RE Demolition of existing structures on-site & erection of 42 No. dwellings with access, parking, landscaping and associated works. This application is a departure from the development plan.

I am writing to you in connection with the above development following recent comments to discharge conditions 10, 11 and to confirm further details relating to condition 20. Following an email from our engineer, I copy their response below again to formally submit the information.

Checked By RW	Checked Date 19.04.2021	Drawn By CLP	Drawn Date 19.04.2021
Client Drawing No. -	Scale 1:200	(AT A1 SIZE)	
PBA Drawing No. 108.5009.706	Revision F

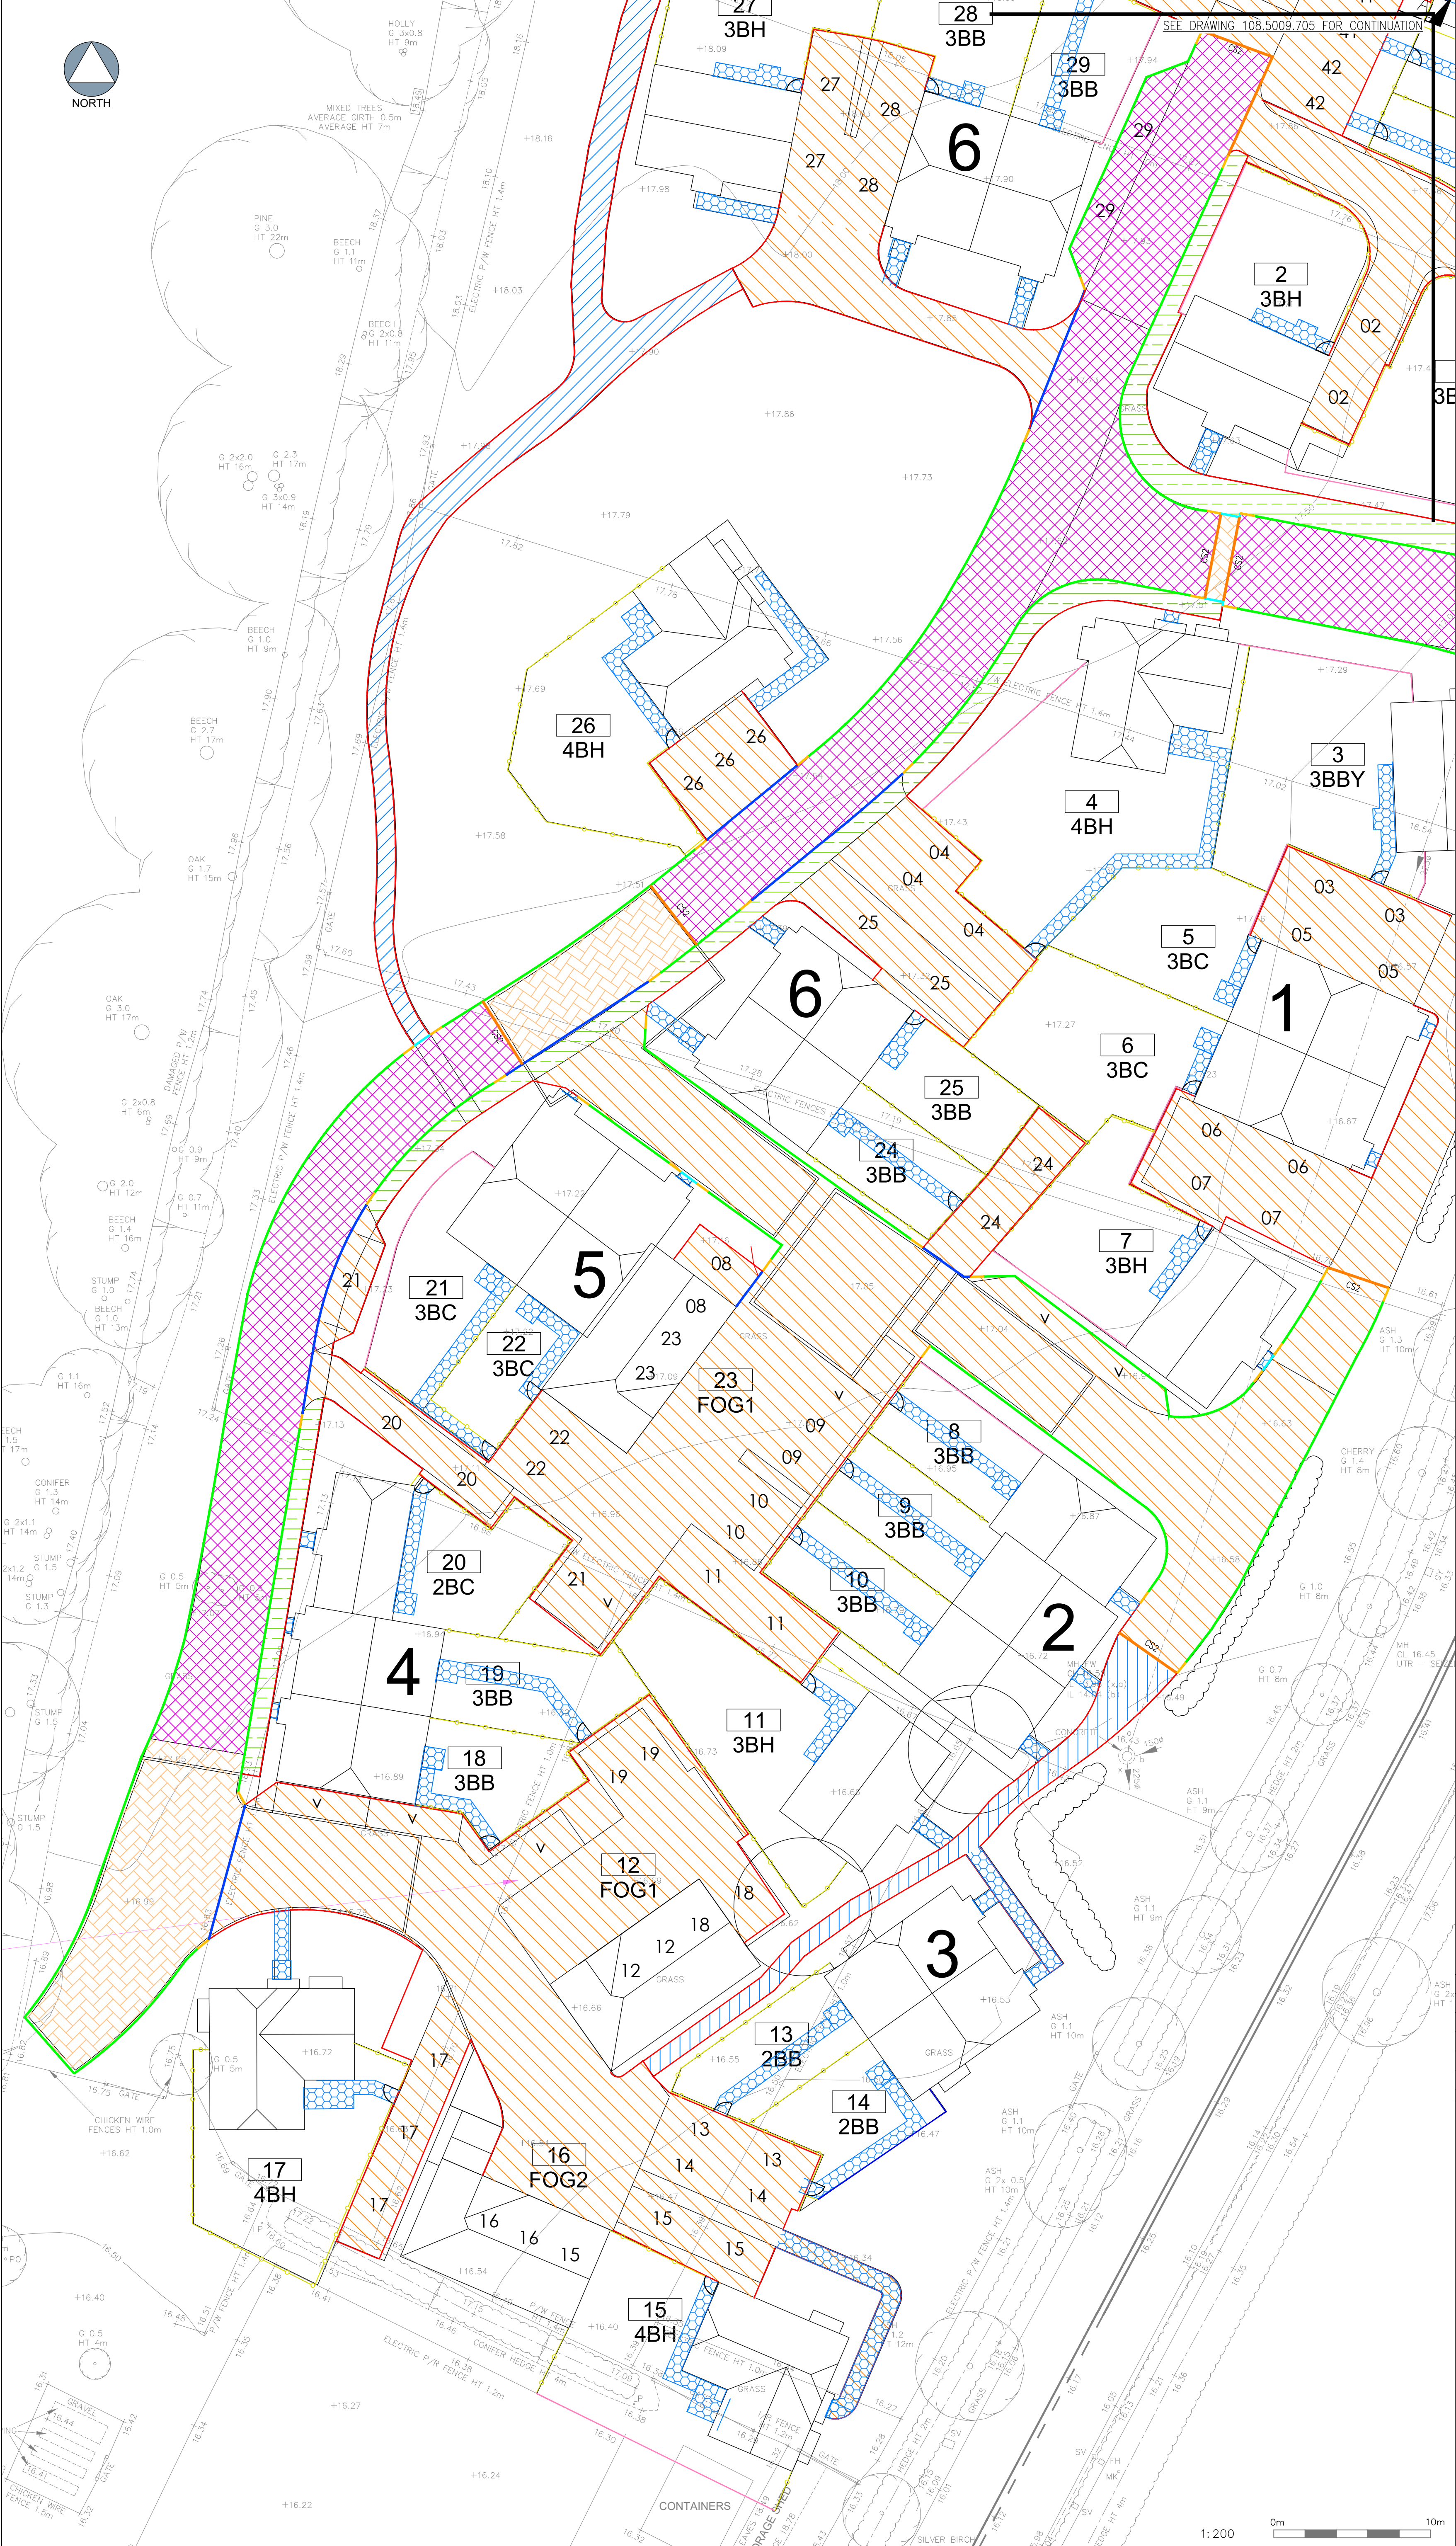
5. Finish and formation levels of permeable paving must be detailed.

The full details of the permeable paving are shown within drawing 751. Drawings 501-506 have been updated to show the construction of the permeable paving within the key. Please also refer to drawing 705 and 706 for full details on the external finishes. Drawings 704 and 703 have now been provided which detail formation levels.

PBA Drawing No. 108.5009.506 Revision F

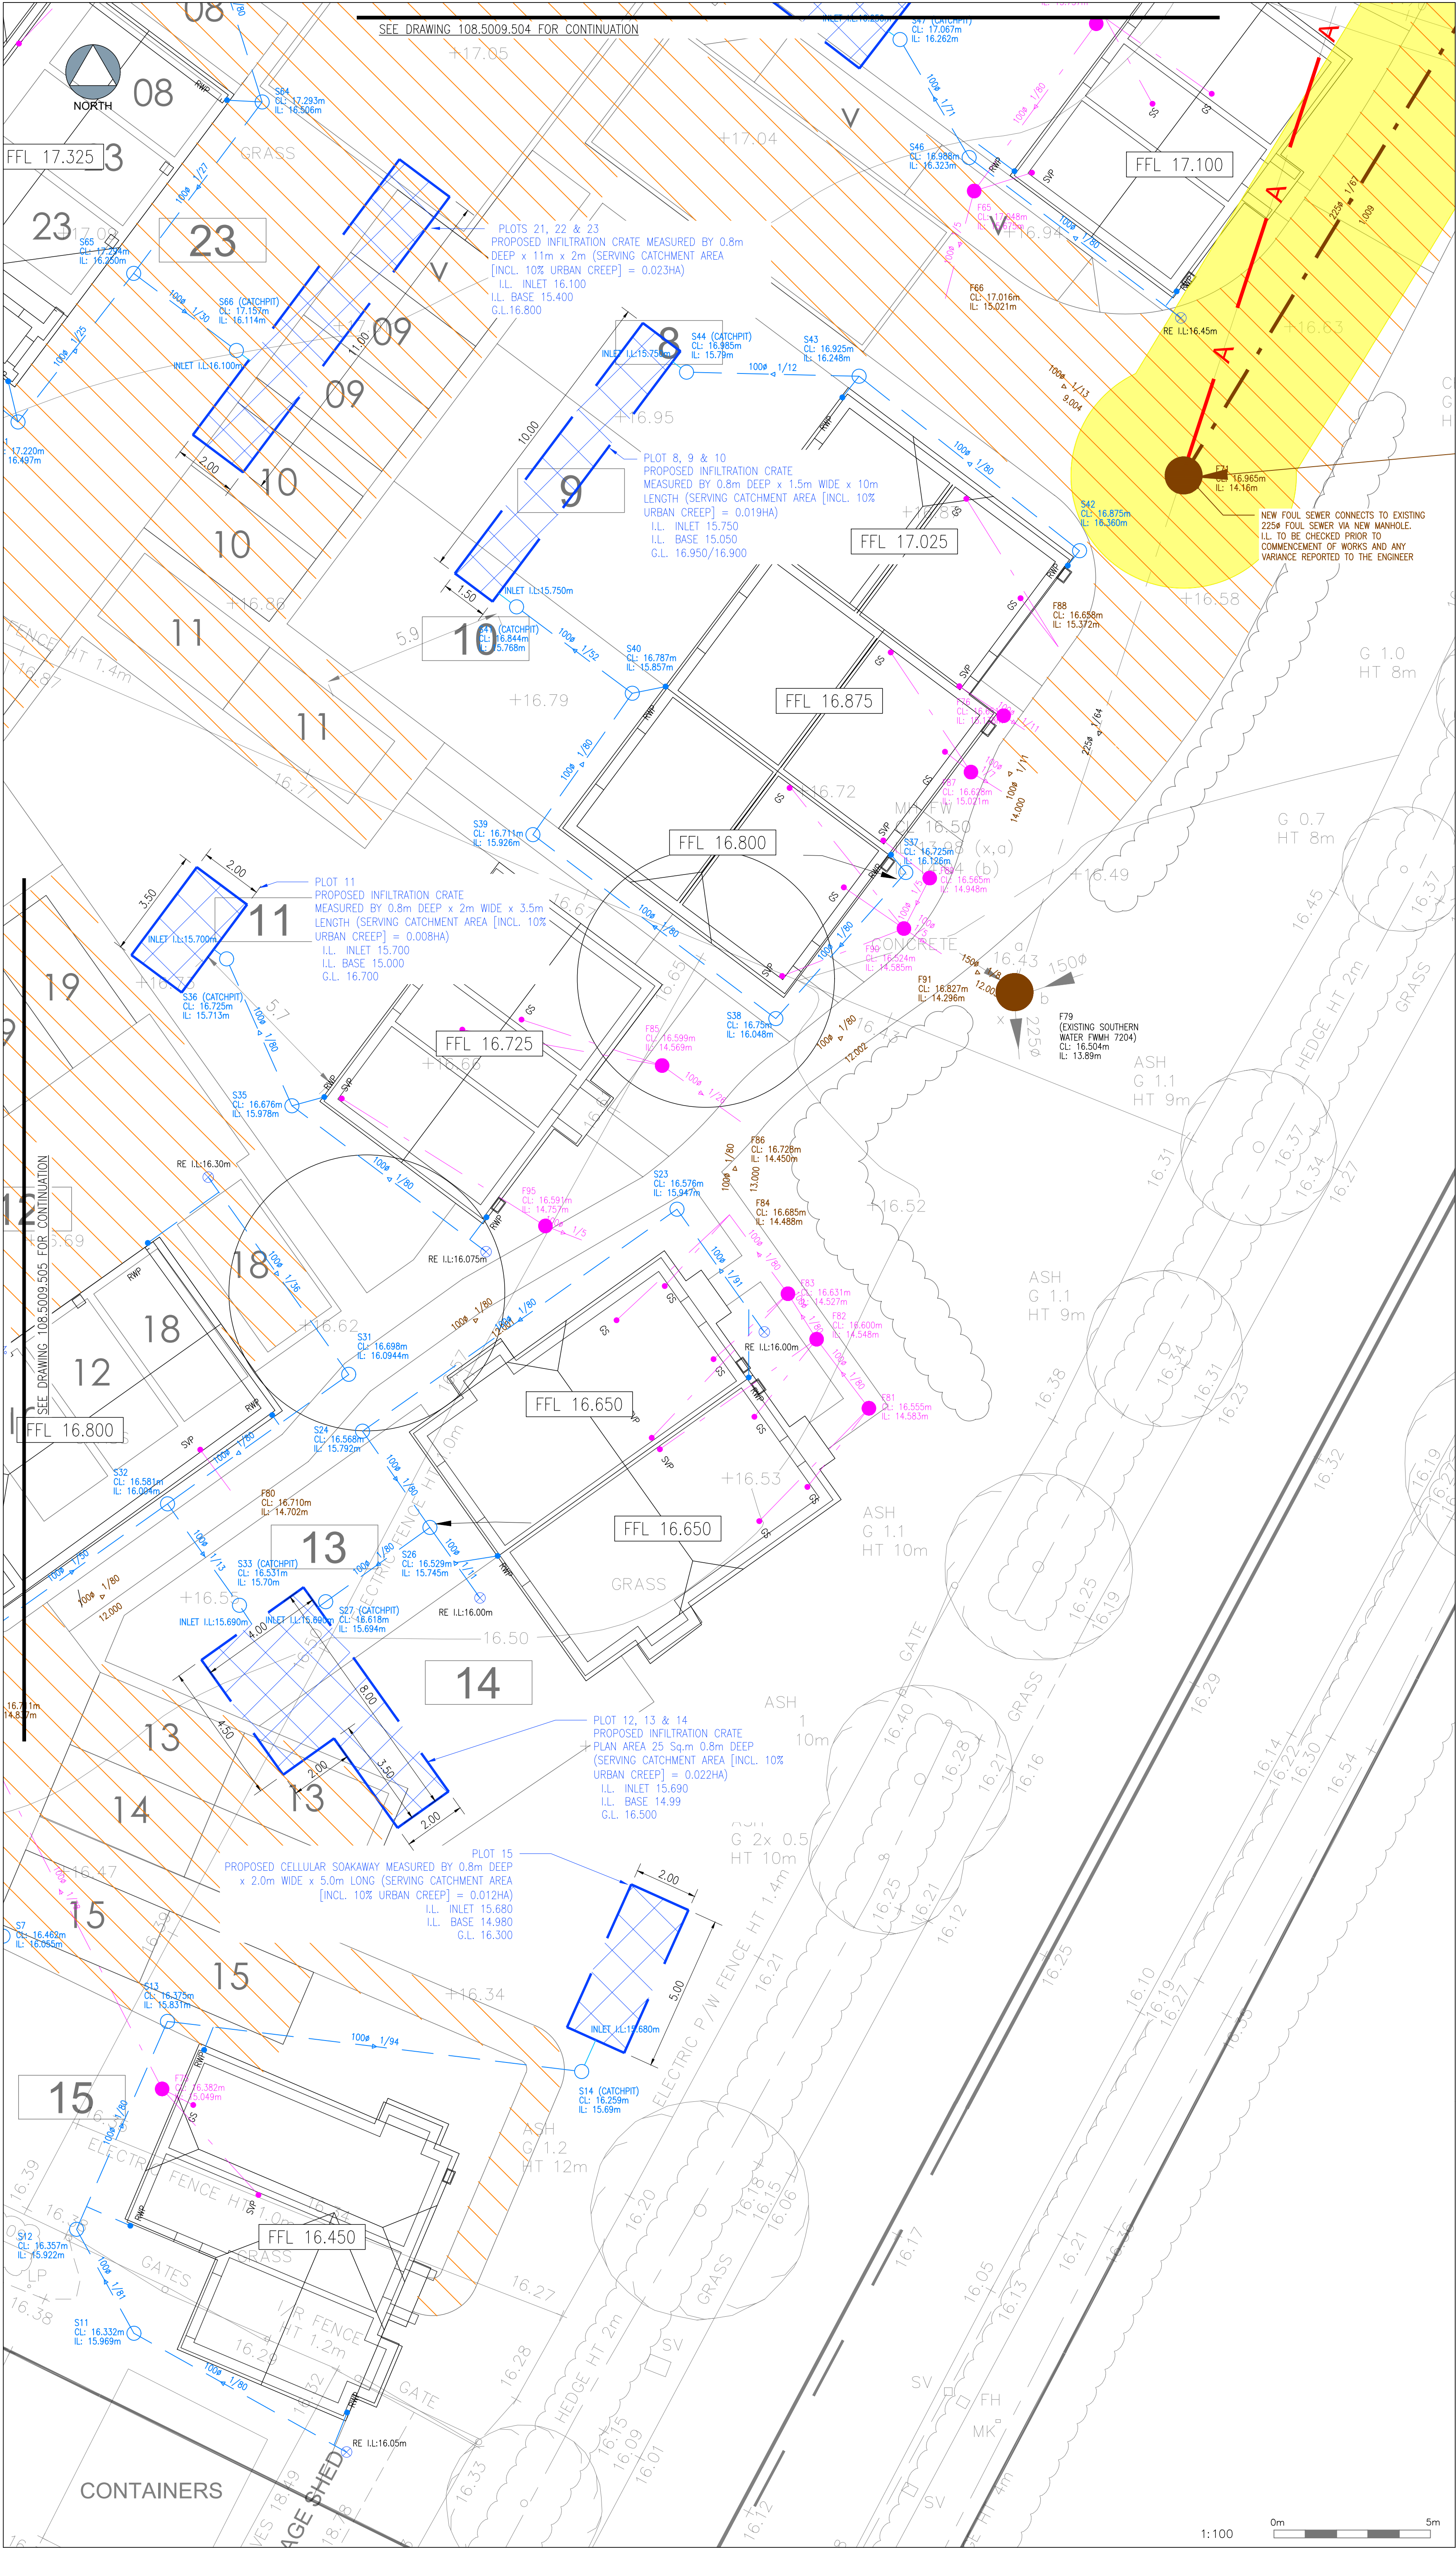
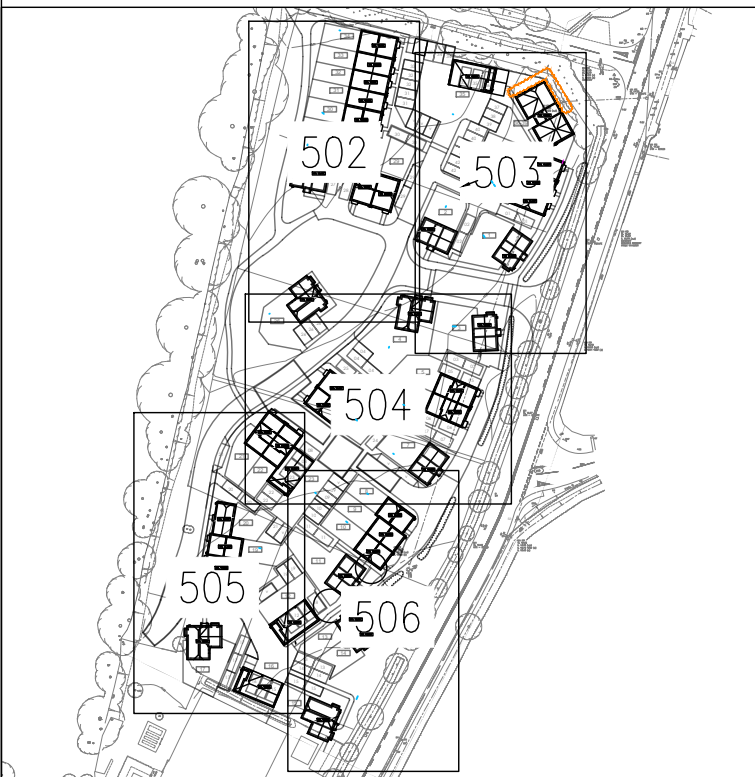
1. Catchpits must be provided upstream of all connections into soakaways. Please clearly show these on plan

2. Detailed drainage layout plans must show crate dimensions, i.e. length, width, depth, invert level, incoming invert level and cover level.

11. Incoming invert levels for soakaway for plots 21-23 is inconsistent between drawing 501 and 506. 506 invert levels are above the top of crate level.

Catchpit annotation has now been added to drawings 502-506.

Drawings 502-506 updated to show crate dimensions.

(9-12) The invert levels of the catchpits upstream of the infiltration crates have been amended to ensure that they fall at no steeper than 1:30 into the crates.
